Our ref: NO/2014/107311/02-L01
Your ref: 3/2014/0996
Date: 12 February 2015

**CHANGE OF USE OF A HAIRDRESSERS SHOP TO A ONE-BEDROOM, GROUND FLOOR FLAT
16 (SPRING GARDENS) CLITHEROE ROAD, WADDINGTON, CLITHEROE**

Drawing Title
PROPOSED GROUND FLOOR PLAN

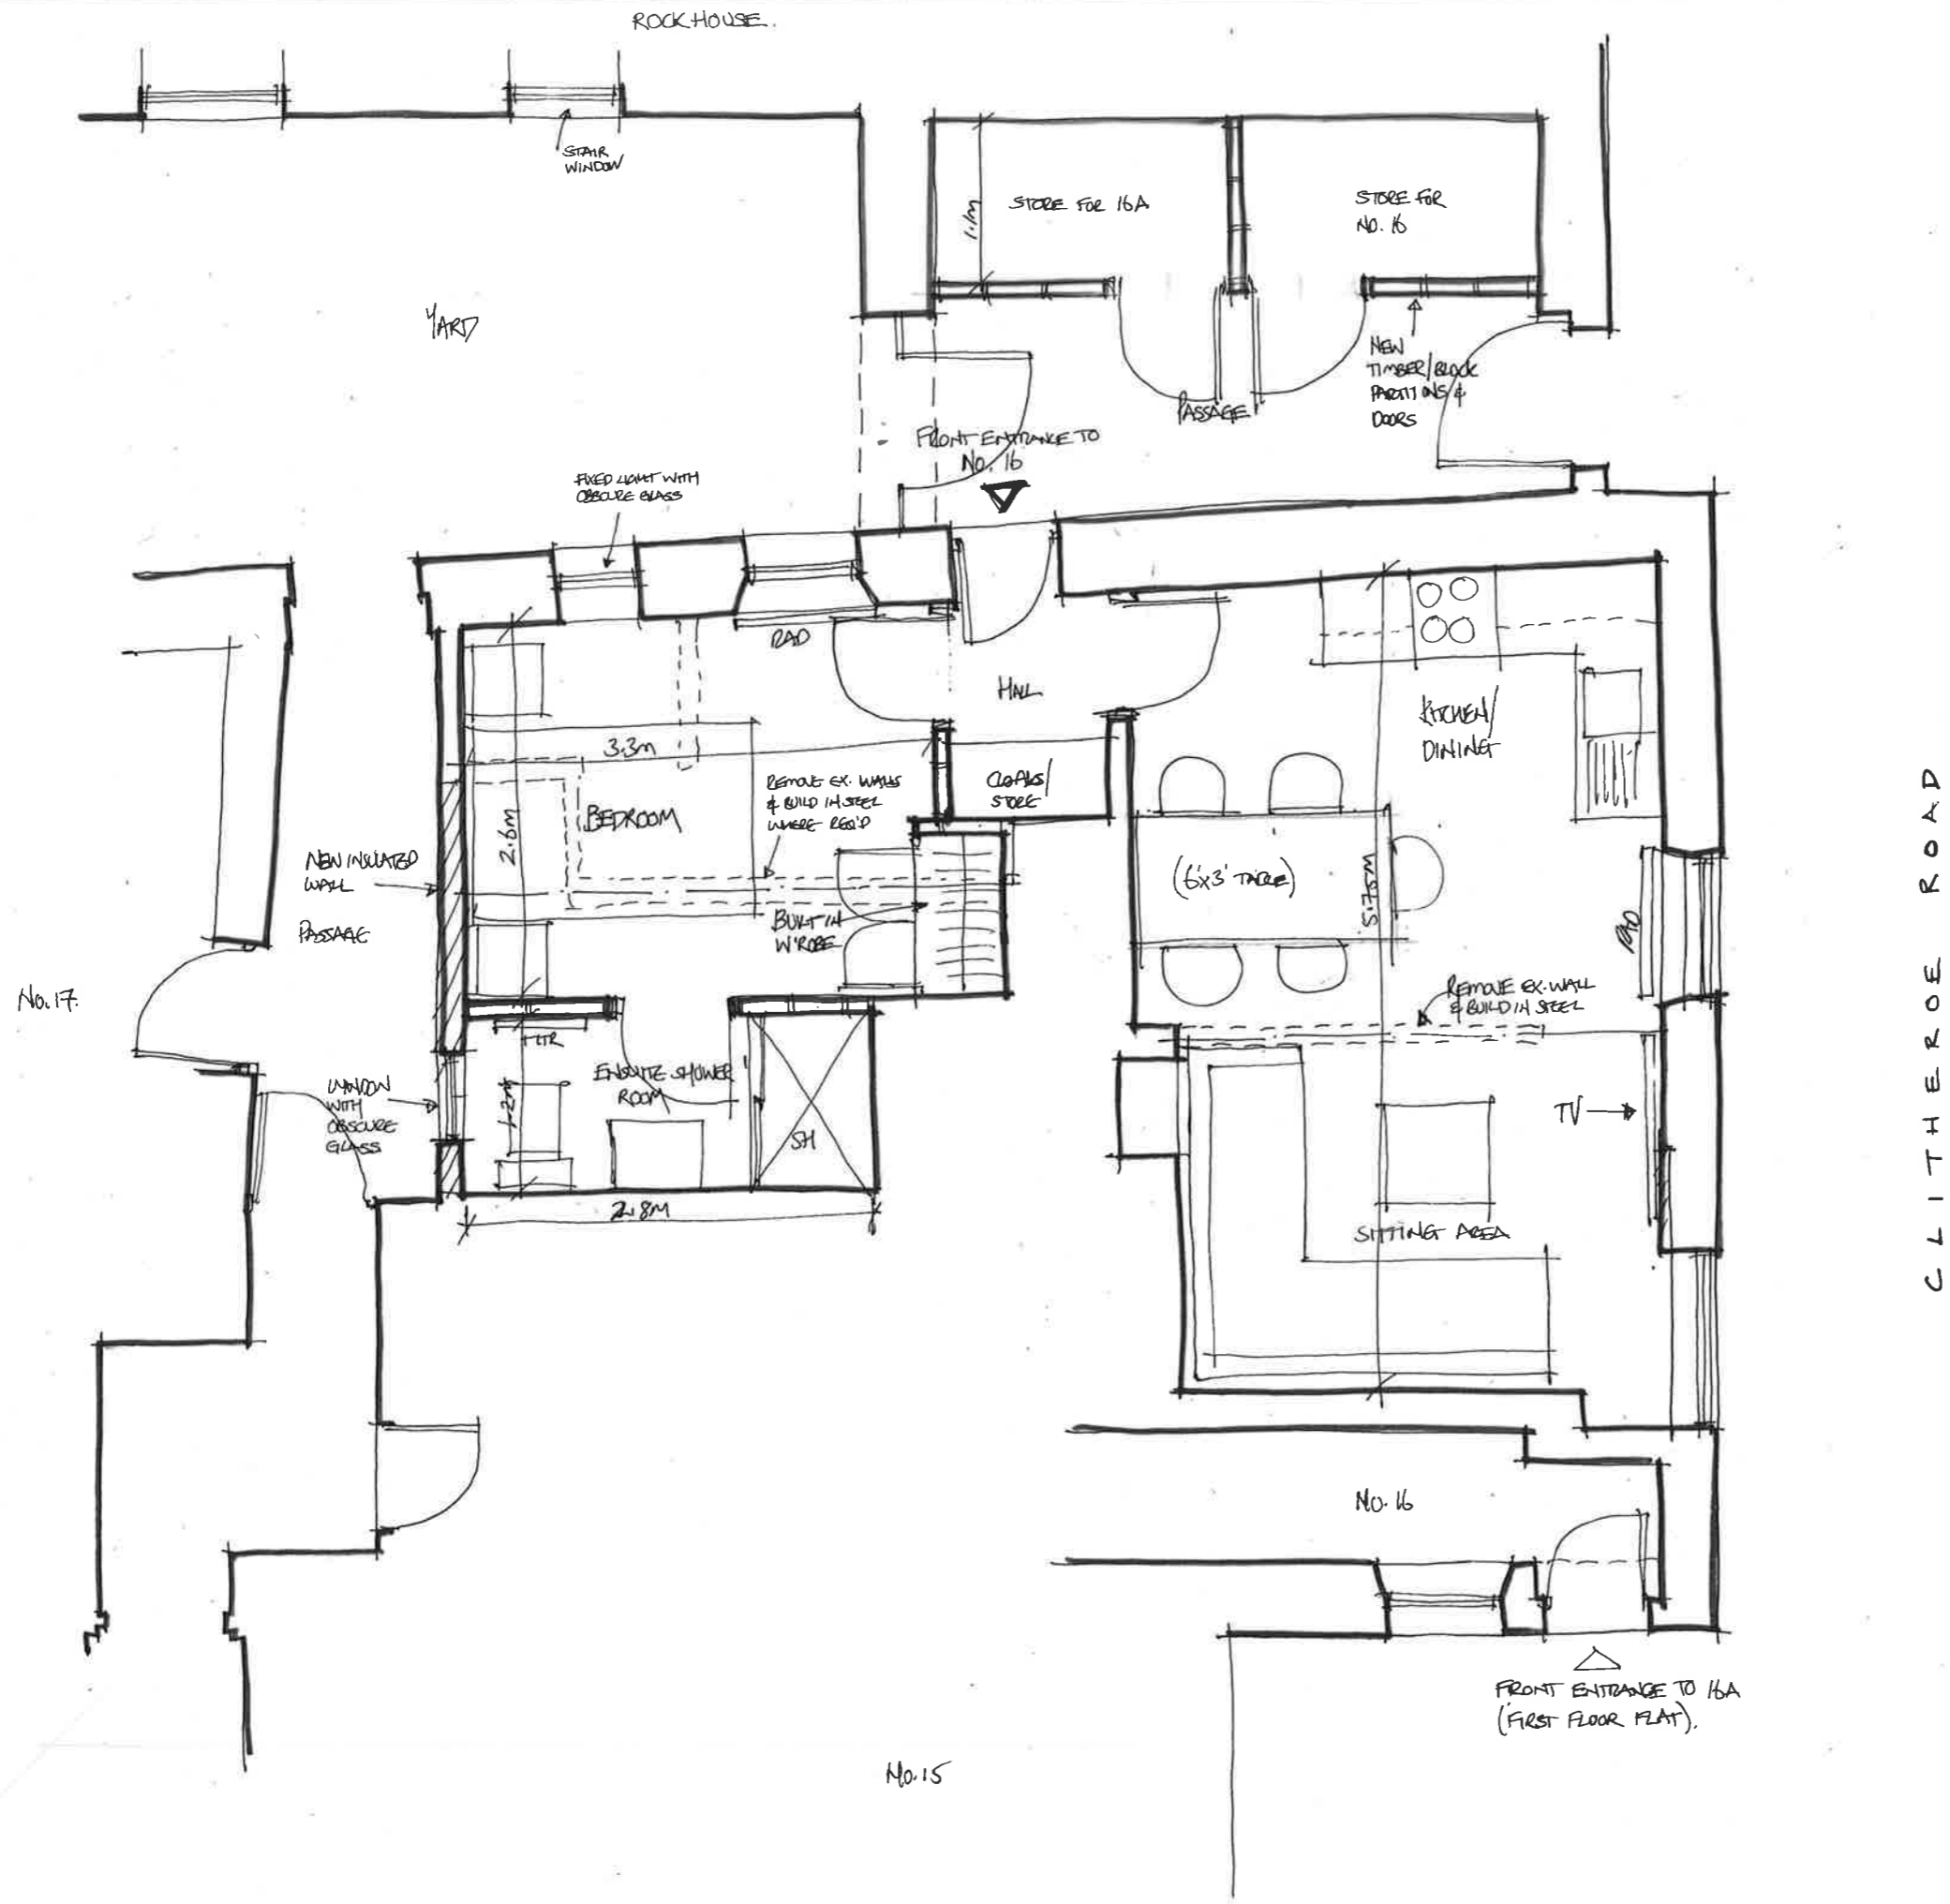
It is now proposed that a permanent 300mm high bund will be constructed across the lobby entrance off Clitheroe Road to reduce the risk of floodwater entering the property. In addition, it is proposed to provide removable flood boards to install across doorways and cover any existing air bricks to provide further mitigation. The revised Flood Risk Assessment (FRA) also identifies a safe access and egress to the site that is available outside the flood risk area.

Based on the mitigation measures proposed in the revised FRA and associated addendum, we **withdraw our objection** to the proposed development but recommend that any subsequent approval is conditioned as follows:-

CONDITION The development hereby permitted shall be carried out in accordance with the approved Flood Risk Assessment (FRA) for 16 Spring Gardens, Waddington by PSA Design (Reference D2019; Job D1935; dated 24 January 2015; Issue 2) and associated Addendum (Reference D2019A; dated 12 February 2015). The mitigation measures detailed in the approved FRA and associated addendum shall be fully implemented prior to occupation or within any other period as may subsequently be
